Dáta | Date  
11 July, 2024

Ár dTag | Our Ref.  
TII24-127595

**Re. Strategic Infrastructure Development – Proposed Windfarm Repowering at the existing Kilgarvan Wind Farm, Inchincoosh, Inchee, Lettercannon, Coomacullen and Cloonkeen, Co.Kerry**

**ABP Case ref. PA08.319741**

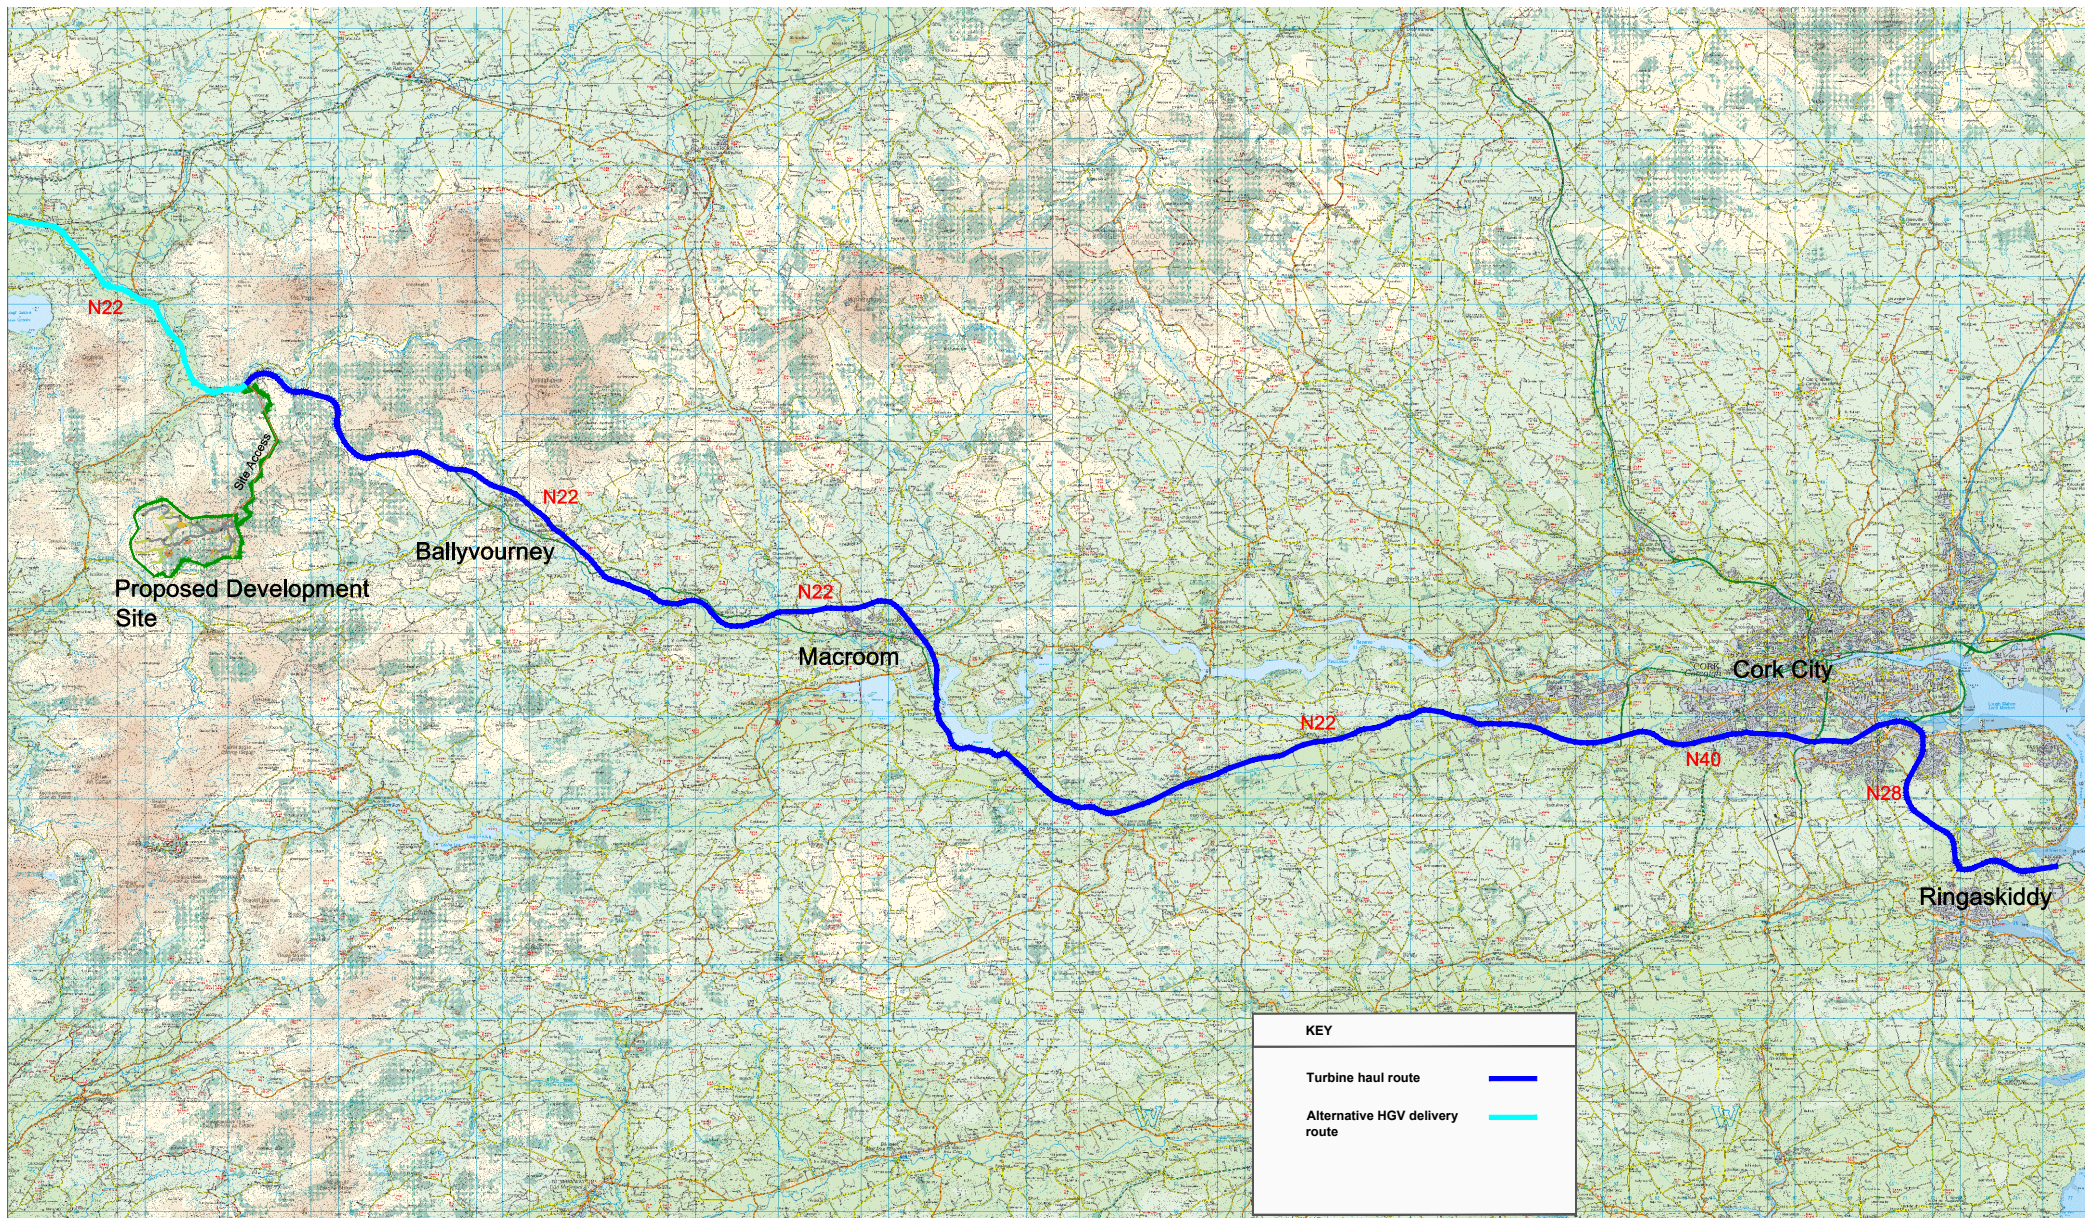
Haul Route proposals for wind turbine component delivery to site are outlined in Section 15.1.2.2; originating from the port of entry at Cork to site via the N28, N40 and N22, national roads.

The applicant/developer should consult with all road authorities over which the haul route traverses to ascertain any operational requirements such as delivery timetabling, etc. and to ensure that the strategic function of the national road network is safeguarded.

TII notes that Section 15.1.8 of the EIAR identifies proposed works to the national road network to facilitate turbine component delivery to site. In the interests of clarification, any proposed works to the national road network to facilitate turbine component delivery to site shall comply with TII Publications and shall be subject to Road Safety

In addition to the foregoing, TII notes the EIAR identifies two options for turbine component delivery to site, one directly from port of entry at Ringaskiddy to site and another option that involves transferring the turbine components from the blade trailer to a blade adapter in order to transport the blade from the site entrance to their intended set down area within the site; Section 15.1.2.2 of the EIAR refers. This latter option involves 'abnormal load' delivery vehicles performing a reversing manoeuvre on the N22, national road, onto a local road to effect the blade transfer between vehicles. TII is concerned that such an approach does not appear to have been subject to any road safety analysis or review as highlighted in item no. 1, above. TII considers that this needs to be addressed.
